WEST SUSSEX COUNTY COUNCIL CONSULTATION

TO:	Arun District Council FAO: Amber Willard
FROM:	WSCC - Highways Authority
DATE:	29 November 2021
LOCATION:	230 Chichester Road Bognor Regis PO21 5BA
SUBJECT:	BE/147/21/A Installation of 1 x internally illuminated mounted tv screen.
DATE OF SITE VISIT:	n/a
RECOMMENDATION:	Advice
S106 CONTRIBUTION TOTAL:	n/a

DRAWING TITLE
ELEVATIONS

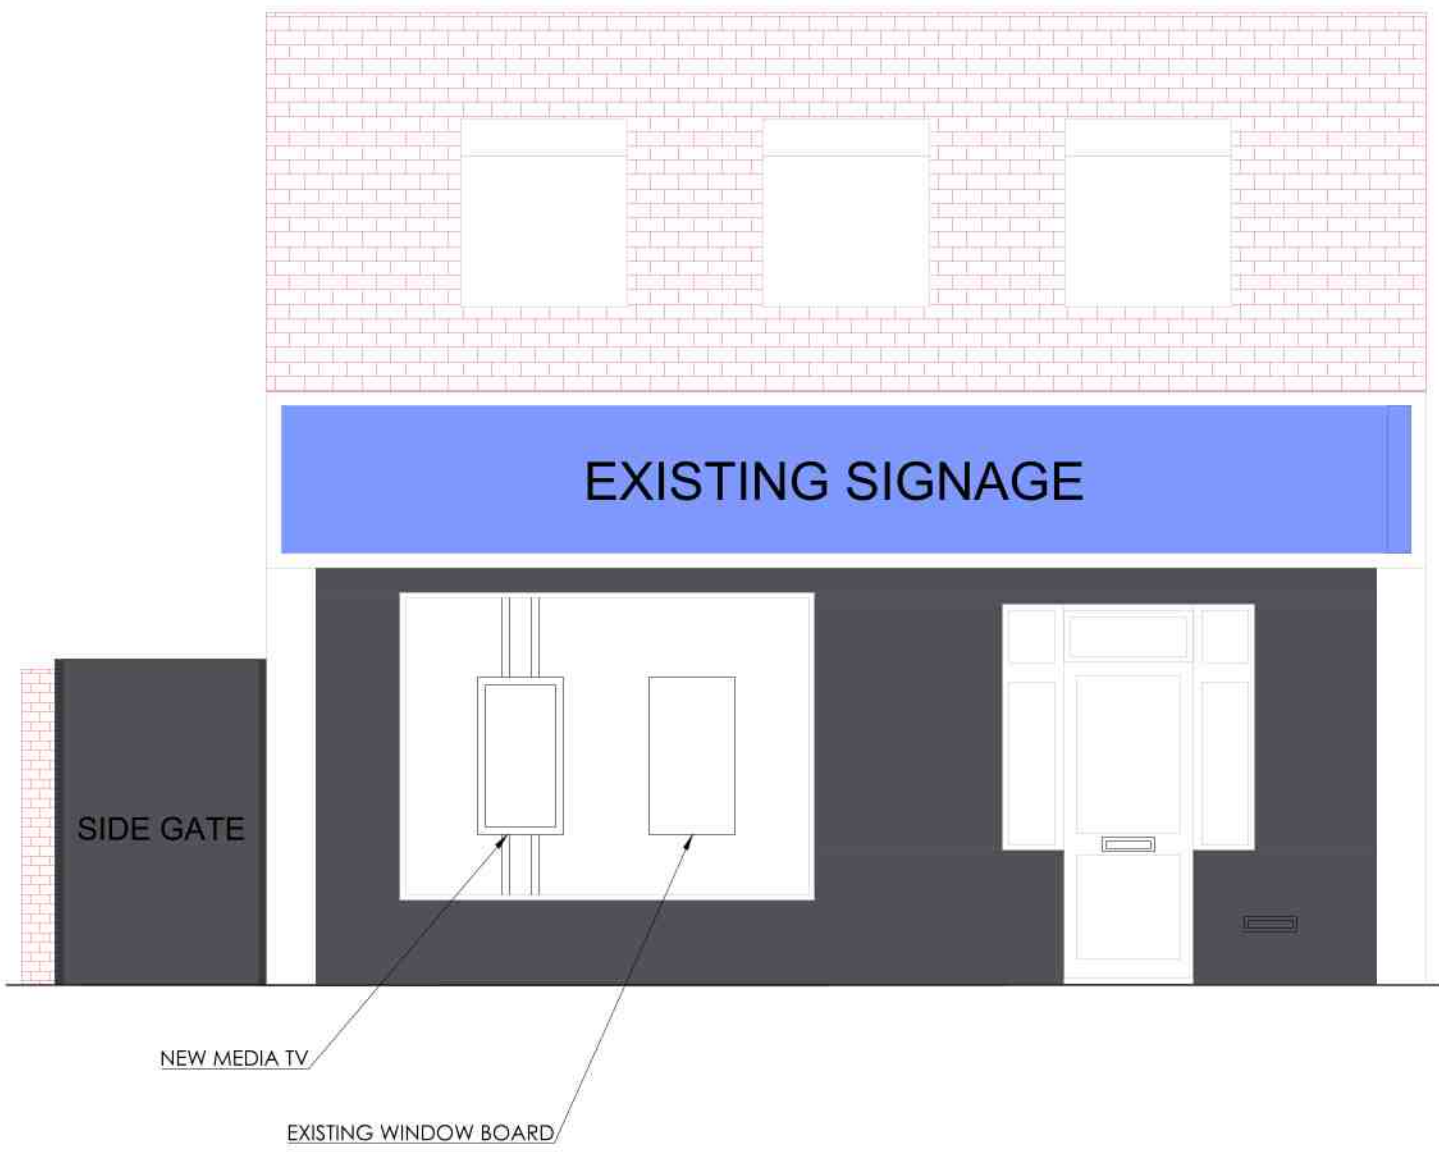
The proposed TV screen will be sited within the window display of the existing retail unit. The TV screen will be illuminated to a maximum of 270cd/sqm which does not exceed the maximum luminance levels of 300cd/sqm recommended by the Institute of Lighting Engineers. The proposed illumination will be intermittent and no further details have been provided. As per the guidance from the Institute of Lighting Engineers 'For digital signs when the content may change, then the rate of change should be limited to once every five seconds. Moving images, animation, video or full motion images should not be displayed at locations where they could present a hazard for example if they could be seen by drivers in moving traffic.'

Given that the proposed TV screen will be visible from the carriageway and therefore could be seen by drivers in moving traffic, the LHA would advise that conditions are applied ensuring that the TV screen does not contain any moving images and limiting the rate of change of images to once every 5 seconds.

2. The intensity of the illumination of the signs shall not exceed 300cd/sqm during the hours of darkness

3. Any change in the advertisement shall be instantaneous and it should not display any moving images.

4. The panels displaying the advertisements shall not change more than every 5 seconds
